Our Reference: IMS 2786173
Your reference: 1009800 and 10_0077
Contact: Allison Cattell
Phone: 02 4732 7909

**Exhibition of Environmental Assessment
Proposed Oily Liquid Waste Treatment Facility
Lot 330 in DP 575290, 10-12 Smith Street, Emu Plains NSW 2750**

I refer to your Environmental Assessment (EA) dated September 2010 (Project No.3439.001) received by Council 26 November 2010.

Figure 2a: Site plan for Unit 2/ 10-12 Smith St, Emu Plains

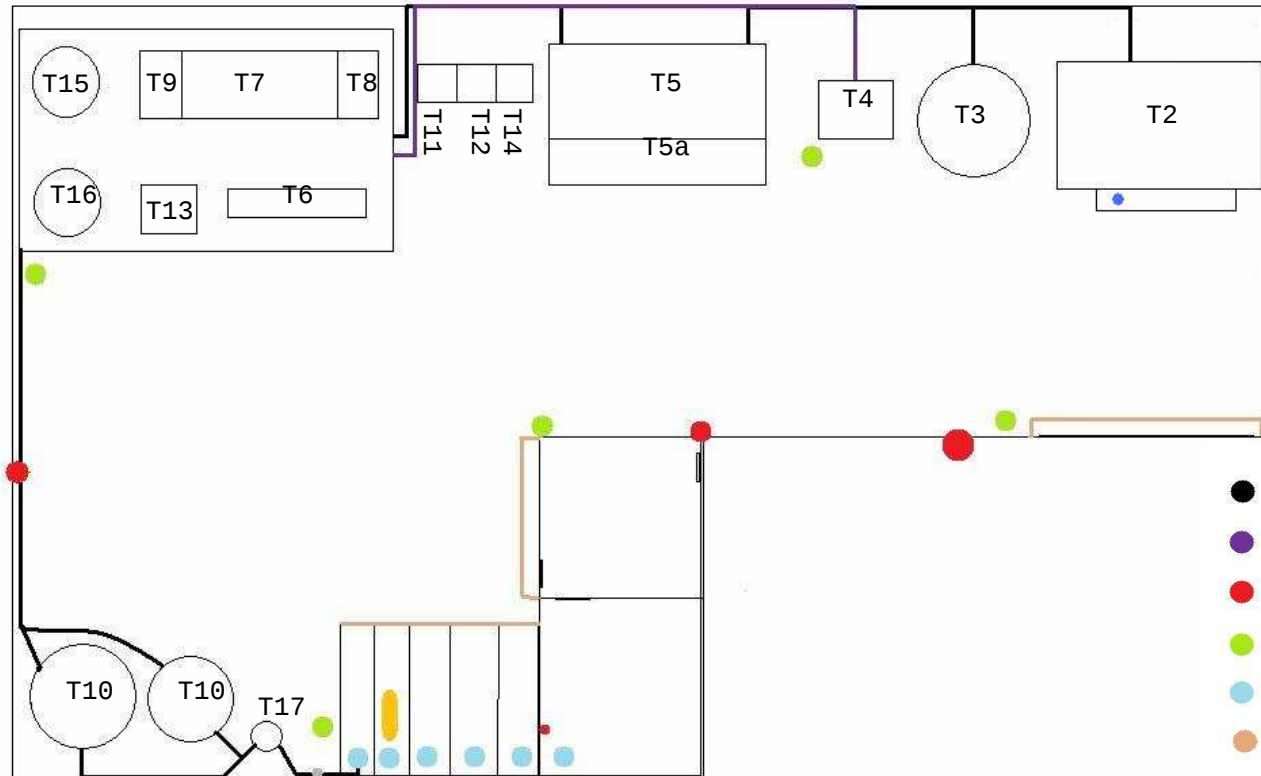
'The Holding Tank, and the pit beneath it, is considered to be the major odour source. The proximity of this source to the roller door is potentially problematic, and could result in short term odour emissions if the door remains open during waste unloading. The design of the Holding tank and pit does not lend itself to full enclosure and capture of a foul air stream for

possible treatment. Similarly, the open design of the DAF renders the enclosure and air capture difficult.'

The report has suggested several odour mitigation measures, however it is very unclear which (if any) of these mitigation measures are going to be employed as part of the proposed development. The report seems to suggest that they would consider these measures if odour becomes an issue once operational. This approach is unsatisfactory as it is environmentally damaging and very difficult to manage from a compliance perspective.

Driving Pattern SK1

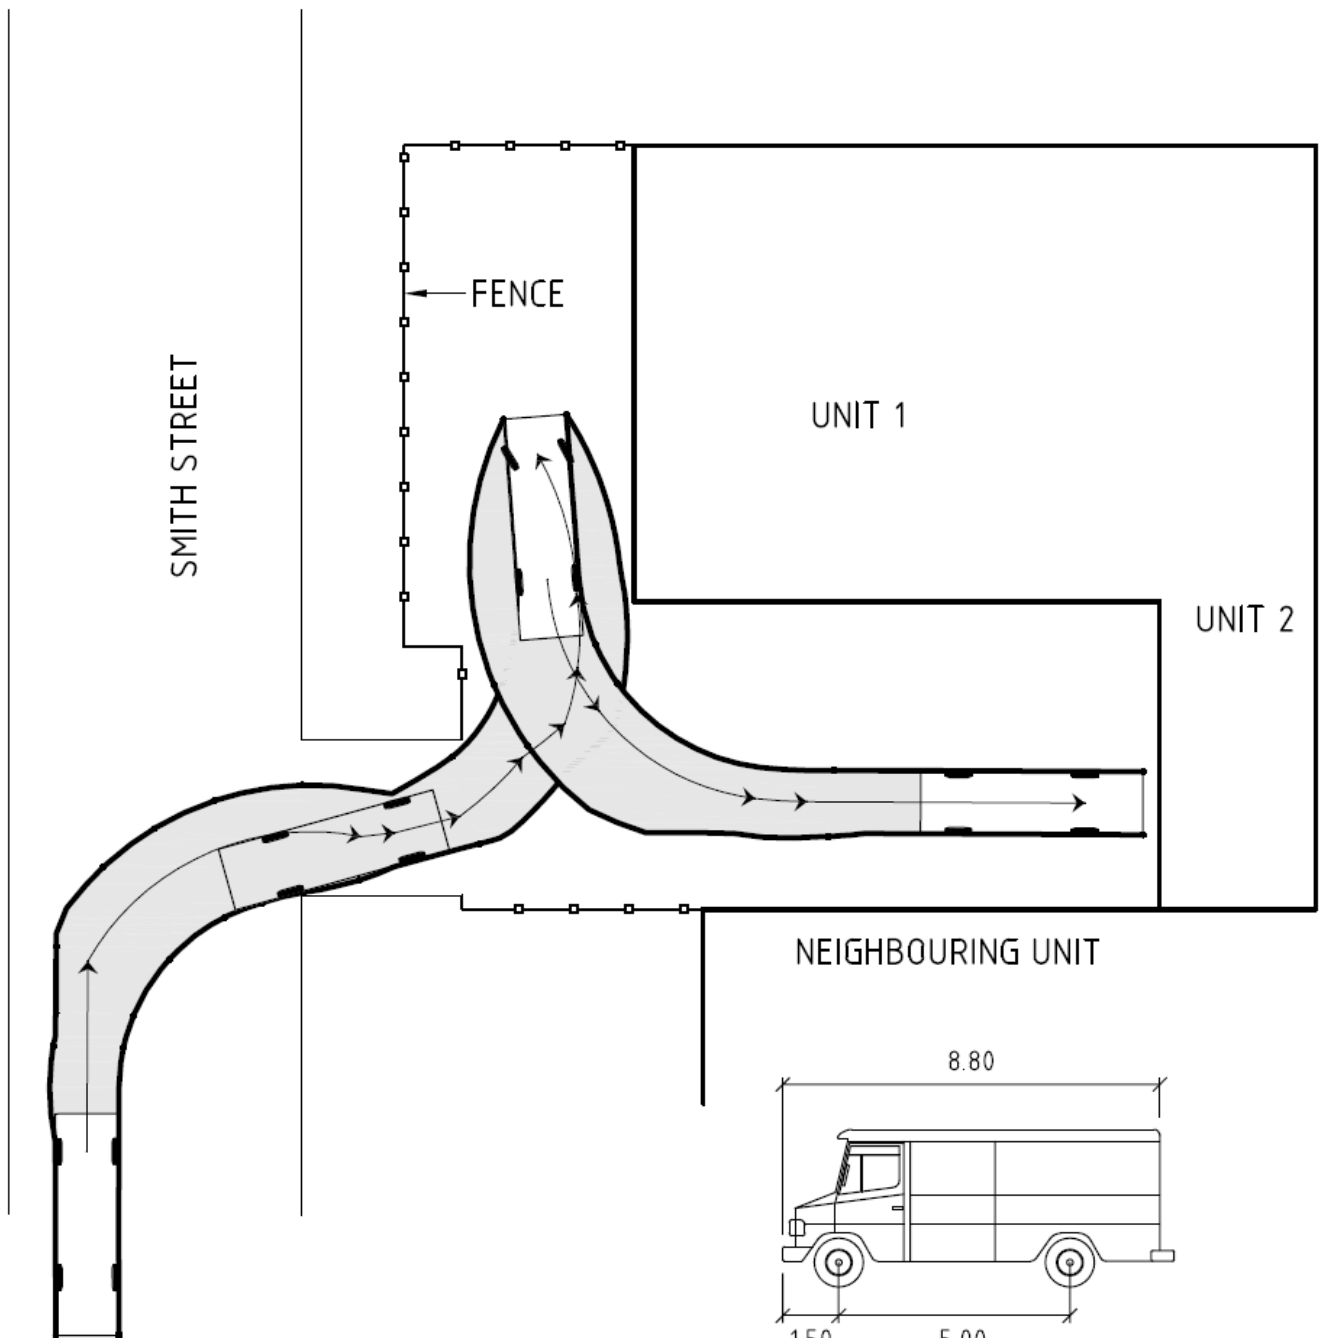
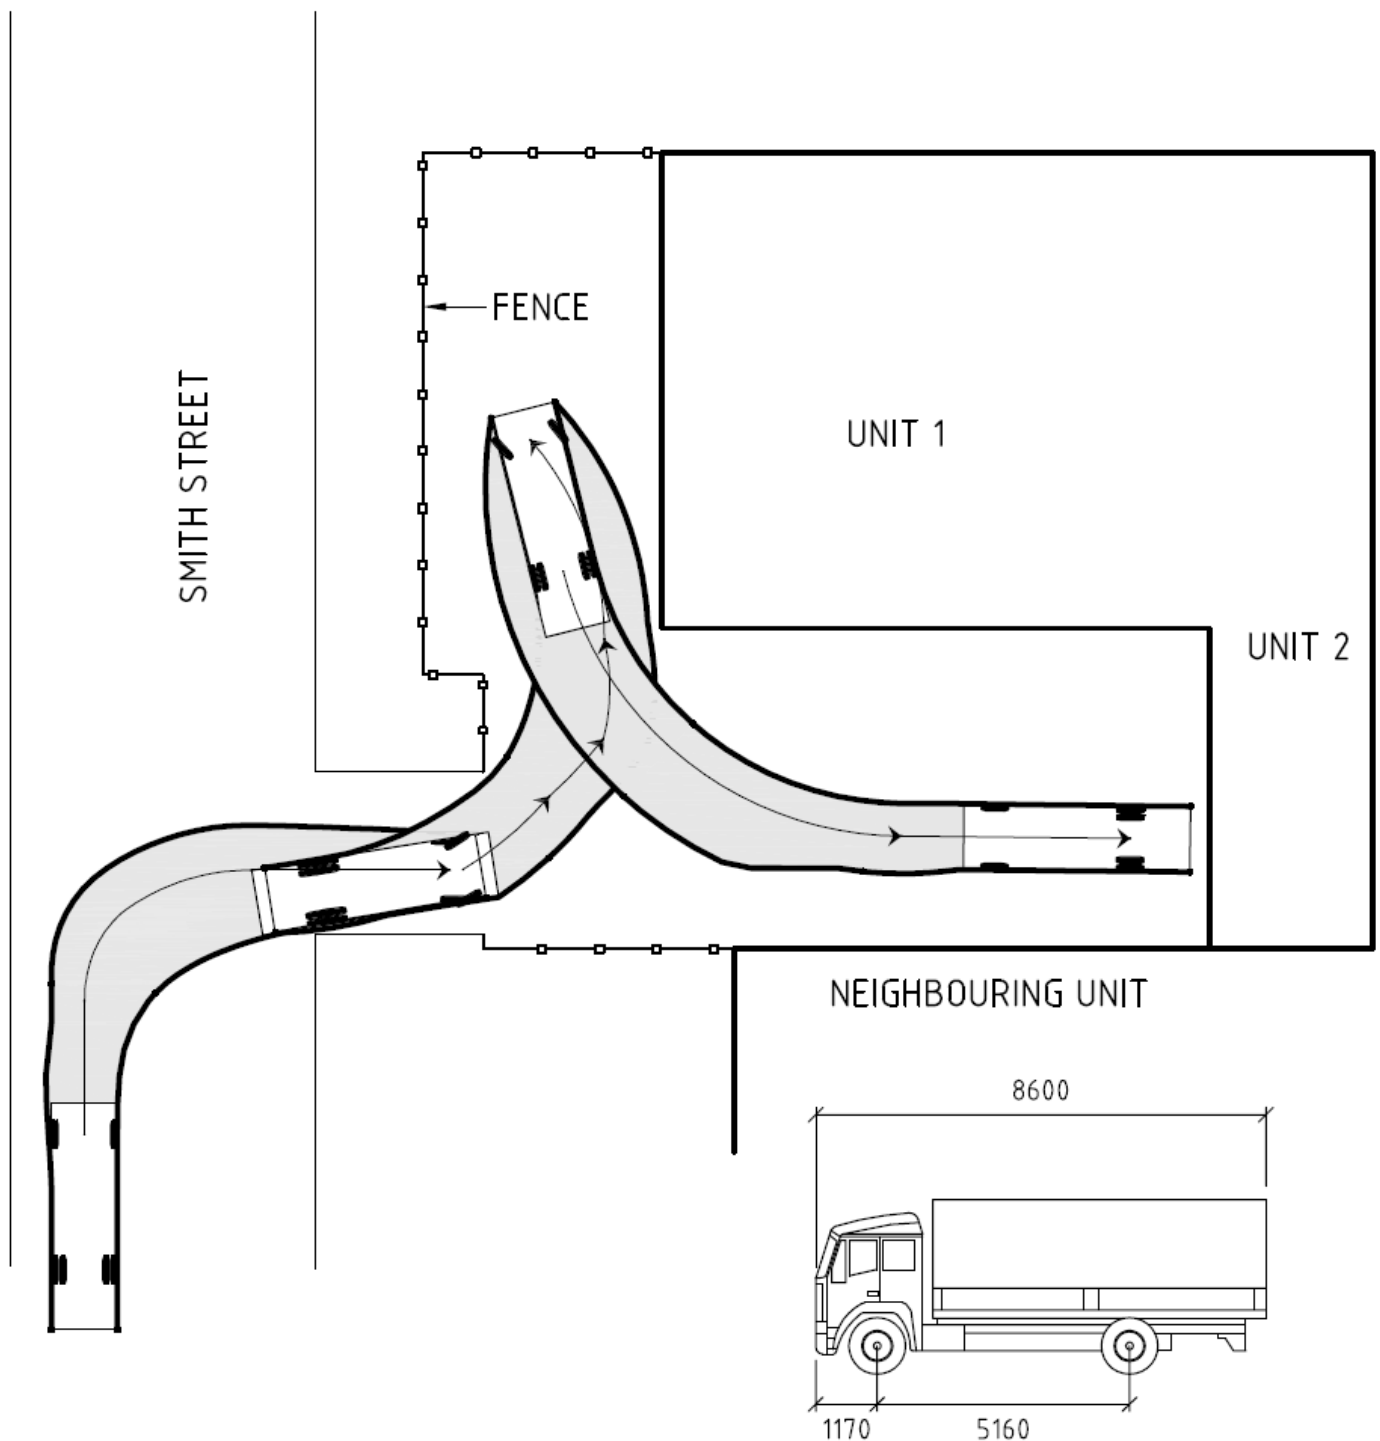
A Traffic Report is recommended to address potential impacts including sufficient car parking provision on site. In particular, truck parking and manoeuvring is to be satisfactorily addressed and service vehicles must be able to enter and exit the site in a forward direction with all manoeuvring occurring on-site. Roads Act approvals will be required for any works within the Smith Street road reserve (vehicular crossings, stormwater and services).
